REF: 22/02068/REM

Location: OS Parcel 7400 Adjoining And South Of Salt Way Bodicote

Objection

Housetype Portfolio – Parcels 1 & 3

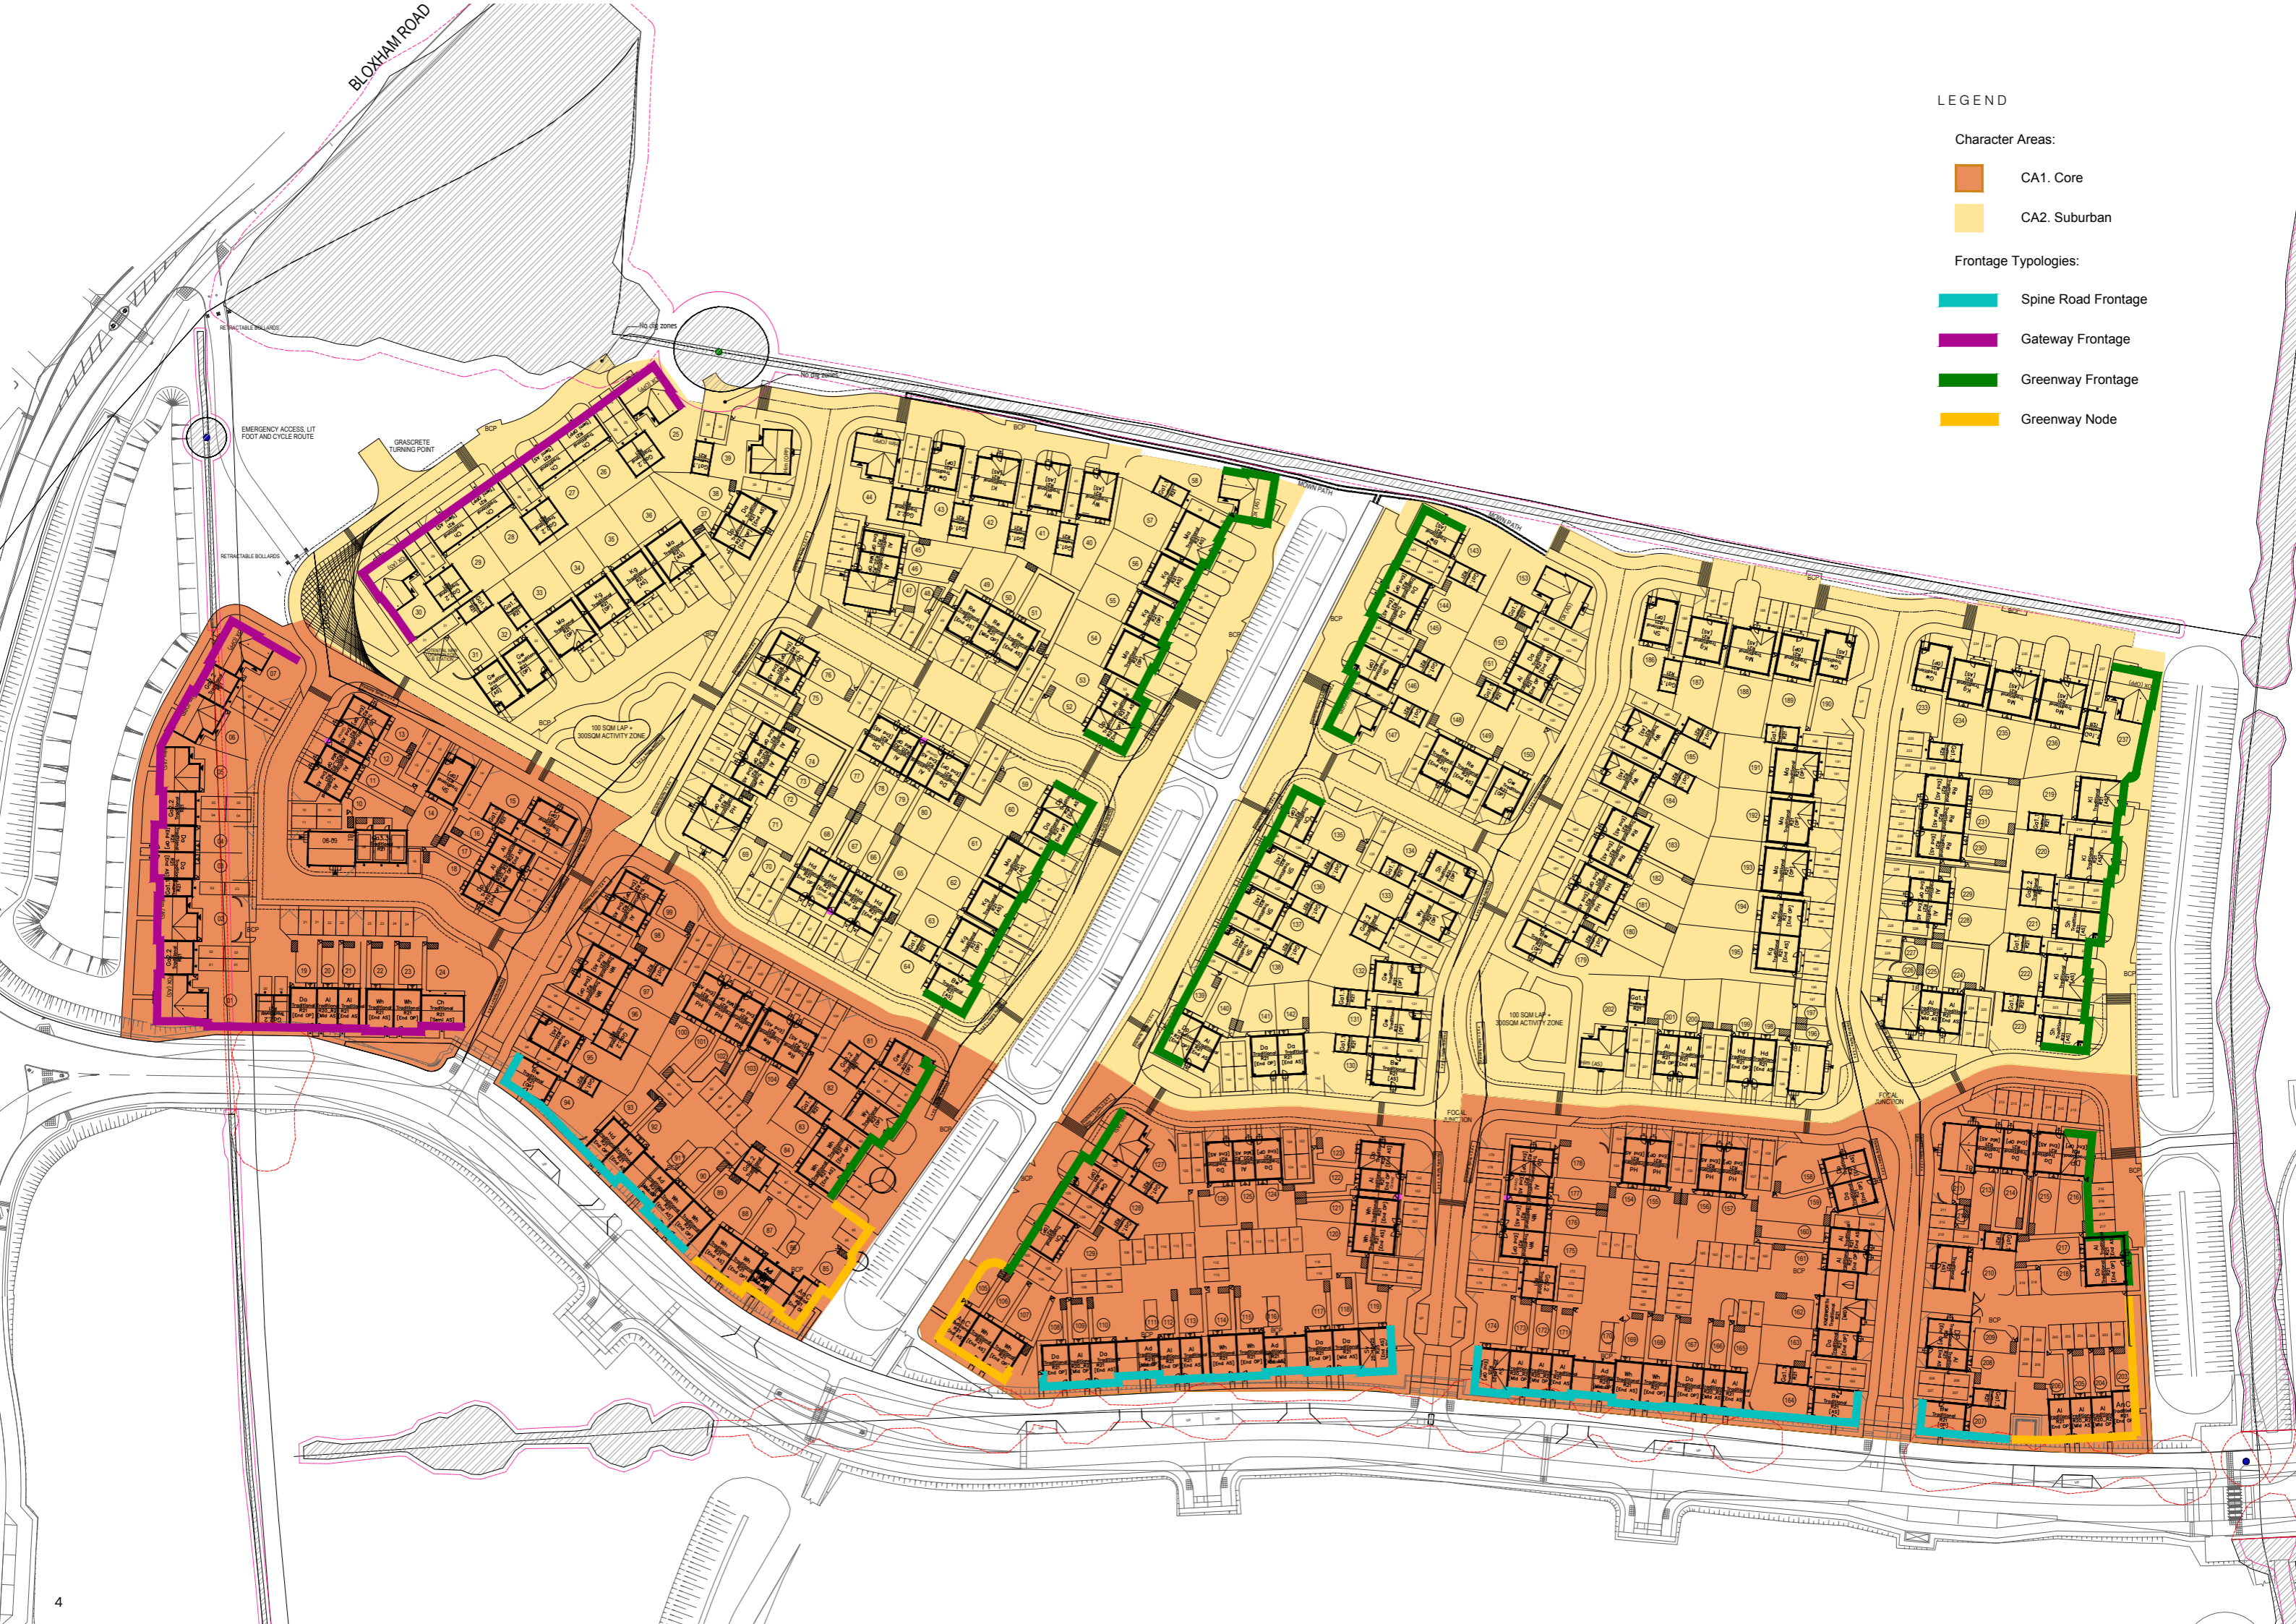
- I have fundamental concerns that excessive use of large rear parking courts, which significantly lack surveillance, leaves large areas of the development very vulnerable to crime and antisocial behaviour.

- I note FOG access to some parking courts appears to be gated, however the size of the proposed parking courts, exposing all boundaries of entire blocks, remains an objectionable proposal.

- Numerous parking courts are excessively permeable, with several possible routes through them or where separate parking courts are interconnected.
- Garages should not be located in rear parking areas where they are not covered by sufficient surveillance to protect them from crime – the garages for plots 1-5 for example are particularly vulnerable to burglary.

- Parking areas commonly lack surveillance – ground floor/first floor obscured windows do not provide any surveillance (plot 20 for example).

- All plots within the block 1-10, 13-20.
- All plots within the block 21-29, 34-41.
- All plots within the block 107-122, 125-131.

- All plots within the block 183-198, 201-205.
- All plots within the block 225-227, 233-240.
- Plots such as 87 and 100

- Bin collection points must be located away from dwelling boundaries, to prevent bins being used as climbing aids over vulnerable side or rear boundaries (behind plot 4 for example).

- Bin collection points, for example next to plot 117 and 119 are located directly next to a parking space creating a risk of damage to parked vehicles and subsequent neighbour disputes. BCP's should be located a sufficient distance from parking spaces to mitigate this risk.

- Plots across the site are vulnerable to crime and unauthorised entry due to a lack of defensible space and planting to protect vulnerable side and rear boundaries which are accessible from the public realm – Plots 1 – 6, 41, 136 for example. There should be clear definition between the public and private realm. Where the public or semi-private realm adjoins private areas of the development, defensible space and planting should be provided. This will provide an area of 'stand-off', marking the change of ownership and therefore the acceptable activity that is associated with it, protecting the privacy and security of occupants whilst reducing the potential for neighbourhood disputes. This is particularly important where parking areas or public spaces abut vulnerable side or rear residential boundaries. Side and rear boundaries are the entry point for the majority of residential burglaries, and should be protected within a secure perimeter block wherever possible to prevent easy access.

- Plots across the development have gable ends overlooking the public realm that do not provide surveillance, as they have either no windows or only obscured glass windows – which obviously provide no surveillance at all to the public realm. Some examples being plot 20, 15, 91-92, 131, 141, 231-233.

- Plots 87, 100 and 149 are left vulnerable, as the main entrance to the dwelling is hidden and isolated, not overlooked from the public highway. It is important that all entrances to dwellings address the public realm and are well overlooked, to protect the entrance and people coming and going from the dwelling.

- The lap opposite plot 74 and 172 is not in a suitably safe or appropriate location. The space is closely bounded on all sides by roads, a crossroad intersection, pedestrian crossing points and driveways where reversing manoeuvres will be required. This location creates a significant number of competing observational demands for drivers, in a very concentrated space, creating a risk of child/pedestrian injury particularly when crossing the road. I have concerns with the proposed proximity of balance play equipment to the road, with a lack of sufficient fencing to prevent incursion into the road.

Parking and block layouts, particularly to the south of the site, must be redesigned to incorporate the following guidance. Wherever possible, in curtilage parking is preferred. In any case, a parking space must be covered by active surveillance from the dwelling that it serves, providing parked vehicles with a capable and appropriate guardian. Locating parking to the rear boundary of the plot should be avoided, as it restricts the opportunities for surveillance and leaves vehicles vulnerable to crime.
